Rezoning Transportation Analysis

Petition Number: 2023-124

Revision Log:

Date	Description
11-21-23	First Review (IW)
12-19-23	Second Review (KC)
01-22-24	Third Review (IW)
02-21-24	Fourth Review
03-04-24	Trip Generation Update
04-24-24	Fifth Review (IW)

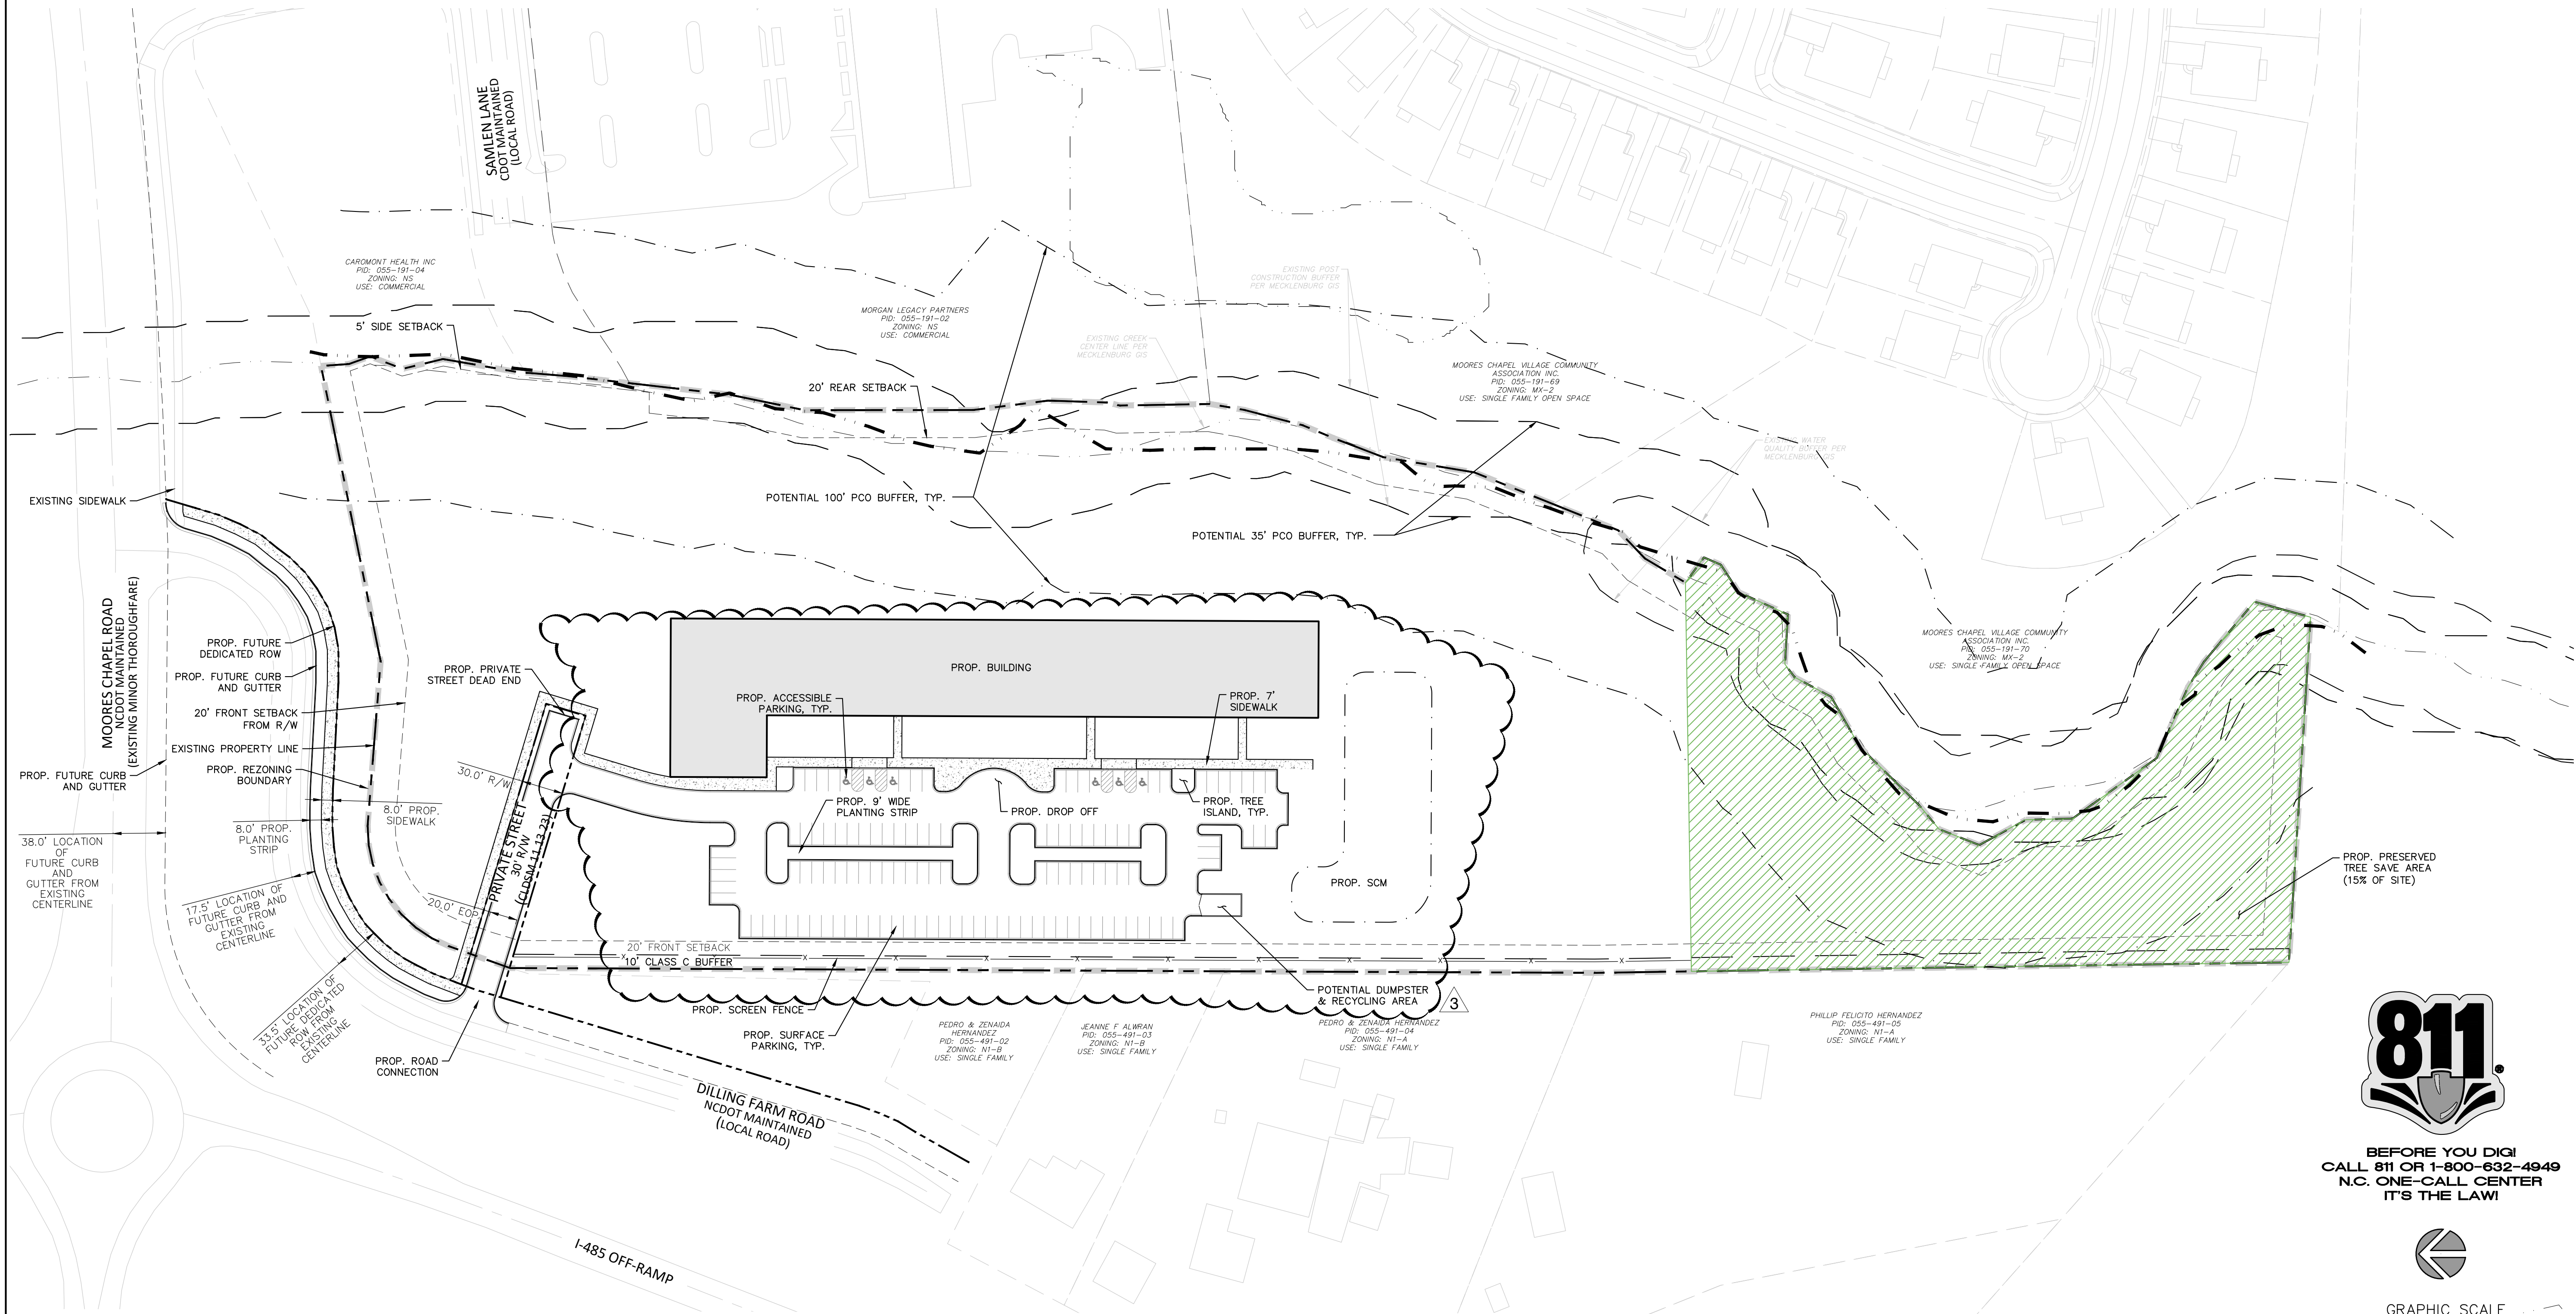
a. ~~**Moore's Chapel Road:** Label and dimension the location of future curb and gutter to be 38' from centerline.~~

b. ~~**Dilling Farm Road:** The location of the future back of curb and gutter to be 17.5' from centerline. The sight plan is to commit to installing as well.~~

~~Label and dimension the curb and gutter from the centerline for each road on the site plan.~~

3. ~~Revise site plan and conditional note(s) to commit to dedicate 33.5' of right-of-way from the road centerline along Dilling Farm Road. The site plan shall label and dimension the right-of-way from the road centerline.~~

5. ~~**Outstanding Comment 11-21-23:** Revise site plan and conditional note(s) to commit to constructing an 8' planting strip and an 8' sidewalk per Article 33 of the UDO and CLDSM U-03A1 along Dilling Farm Road.~~
~~**Clarifying Comment:** Site plan does not show 8' planting strip and an 8' sidewalk per Article 33 of the UDO and CLDSM U-03A1 along Dilling Farm Road.~~

6. ~~Revise site plan and conditional note(s) to commit to making “Public Road 1” a private road per coordination with Subdivision.~~
